# MONA OFFSHORE WIND PROJECT

## Schedule of Changes to Plans

Application Reference: EN010137

Document Reference: S\_D1\_29

Drawing Title:
LAND PLAN - ONSHORE
SHEET NUMBER: 6

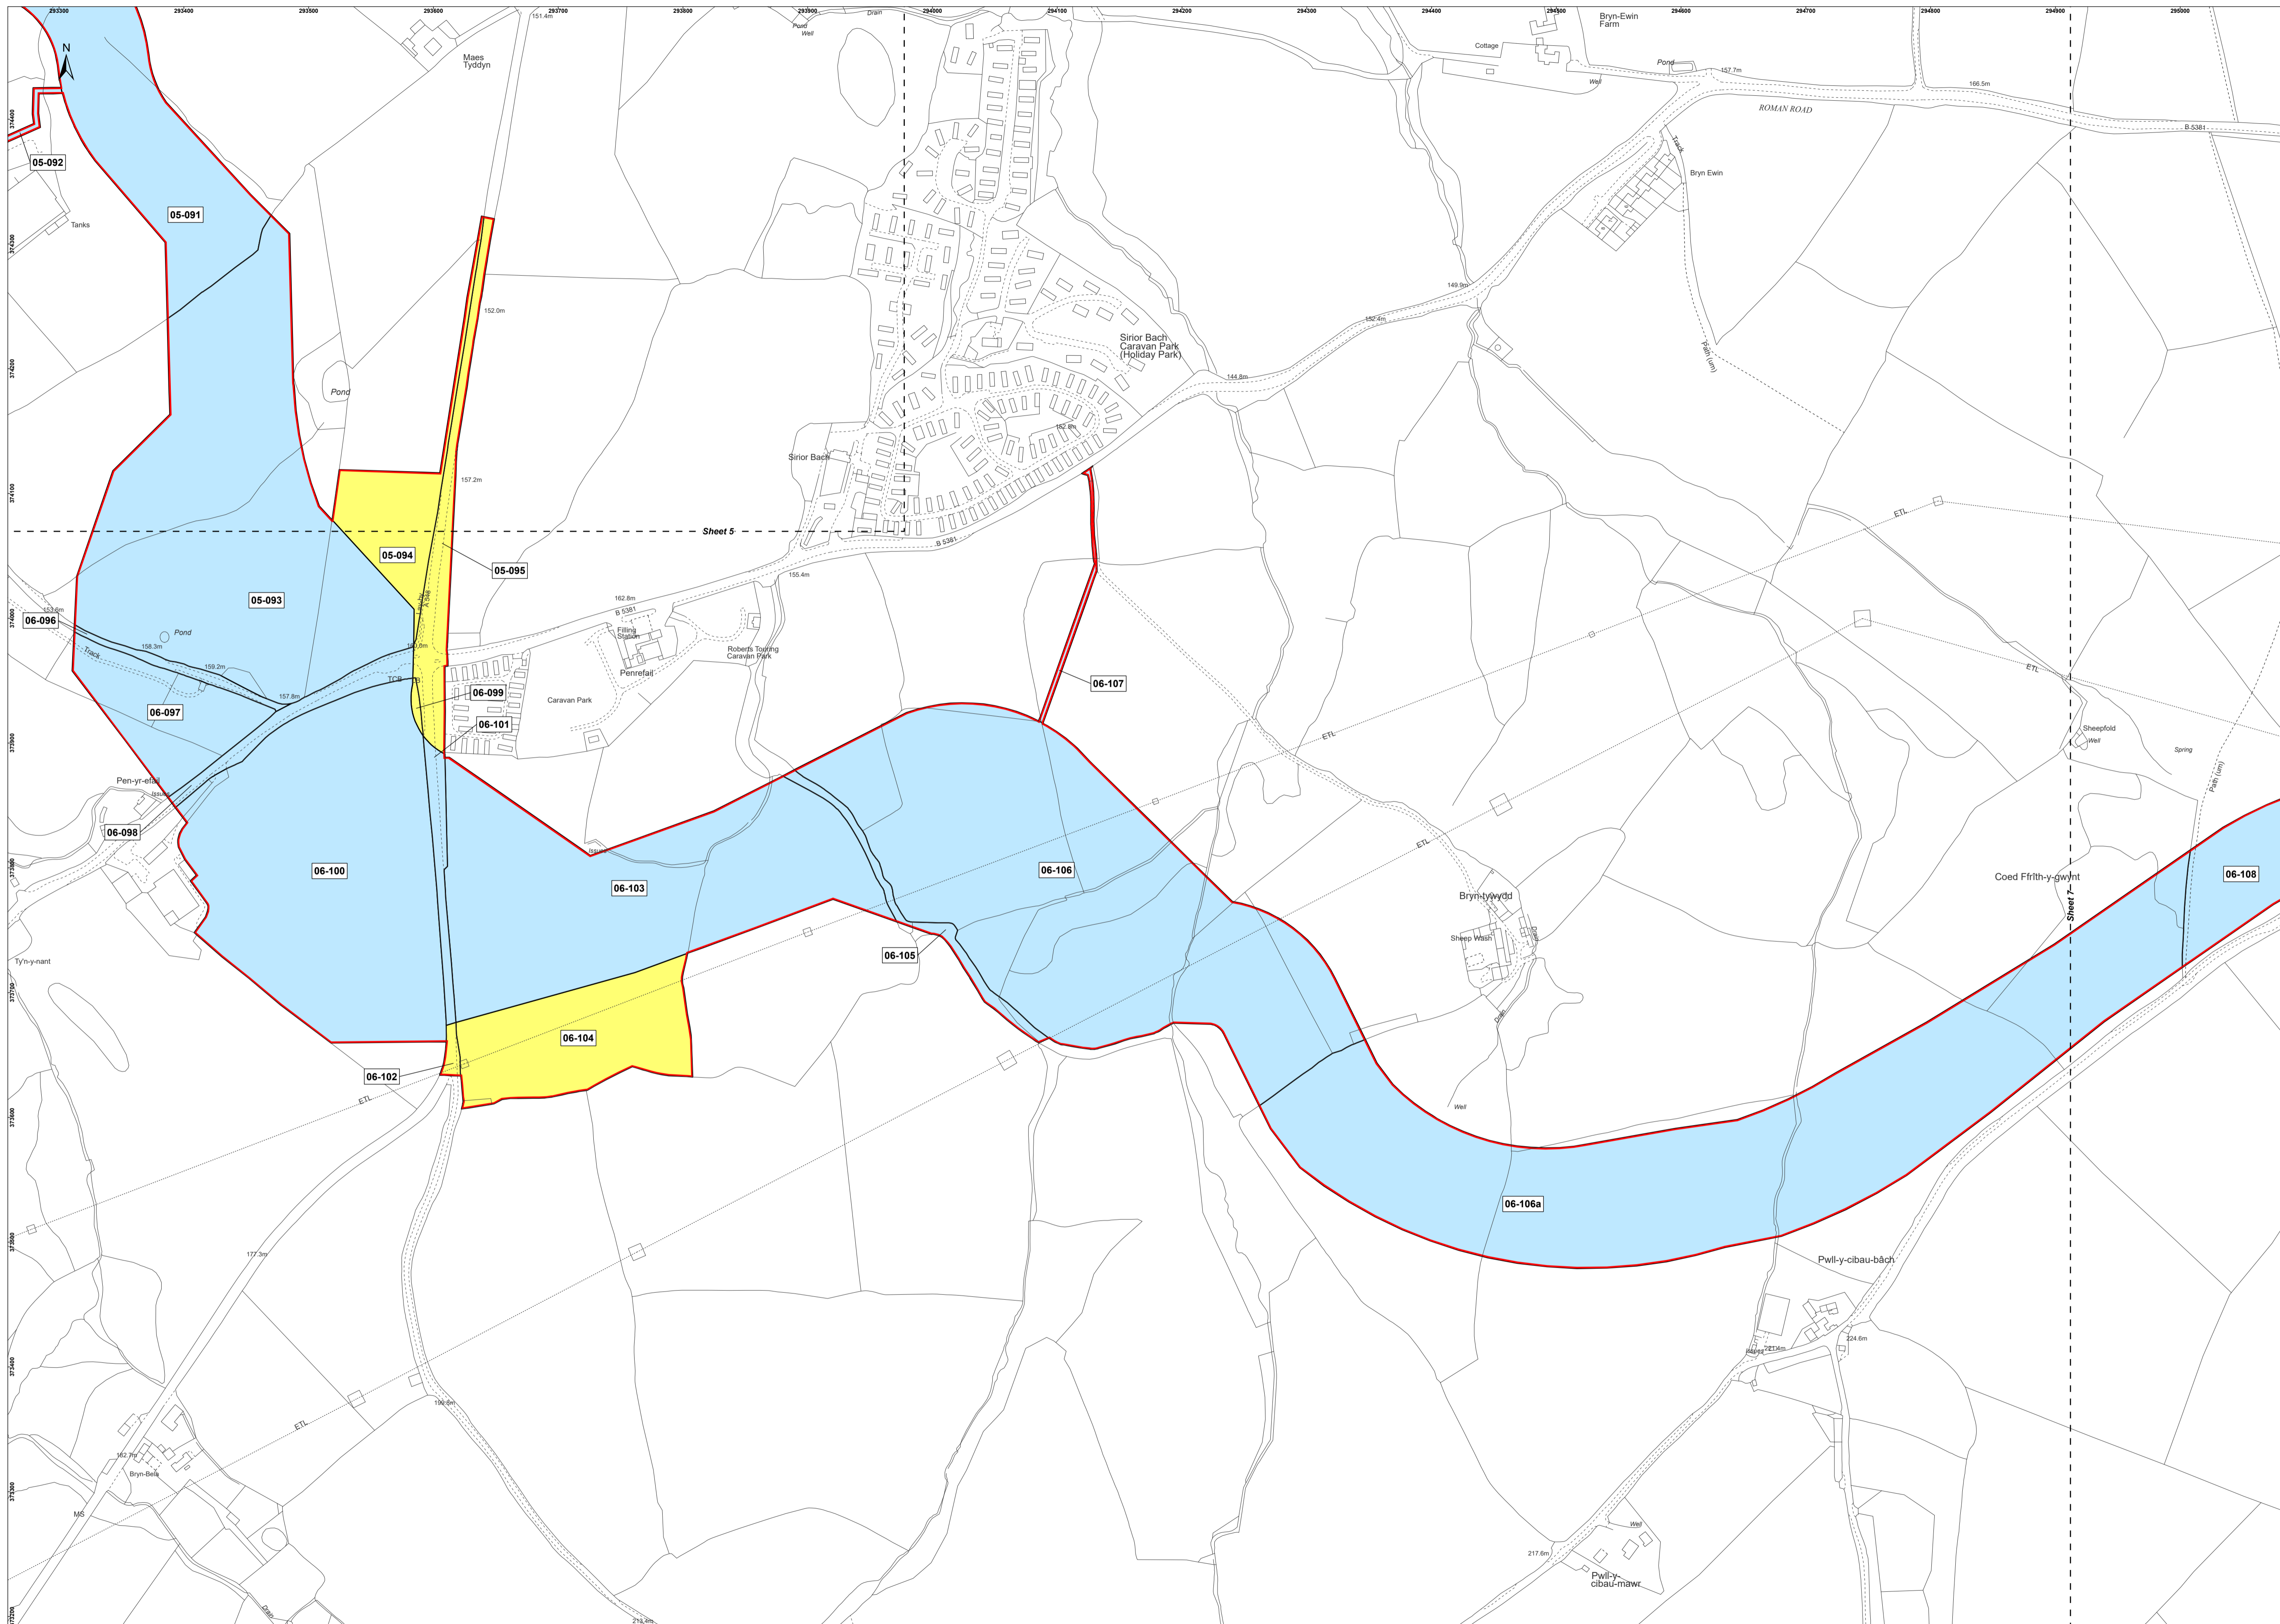
<b>Page Number</b>	<b>Plot Number</b>	<b>New Plot Number(s)</b>	<b>Date of Change</b>	<b>Change Made</b>	<b>Reasons for Change</b>	<b>Revision</b>
6	06-106	06-106a	10/05/2024	Plot split on plans, new label added and key updated to include new plot number	Ongoing due diligence has identified additional partial interests on the title	F02
7	06-106	06-106a	10/05/2024	Plot split on plans, new label added and key updated to include new plot number	Ongoing due diligence has identified additional partial interests on the title	F02
9	09-173	09-173a, 09-173b	16/07/2024	Plot split on plans, new label added and key updated to include new plot number	Ongoing due diligence has identified that the highway extents used were incorrect	F02
10	09-173	09-173a, 09-173b	16/07/2024	Plot split on plans, new label added and key updated to include new plot number	Ongoing due diligence has identified that the highway extents used were incorrect	F02
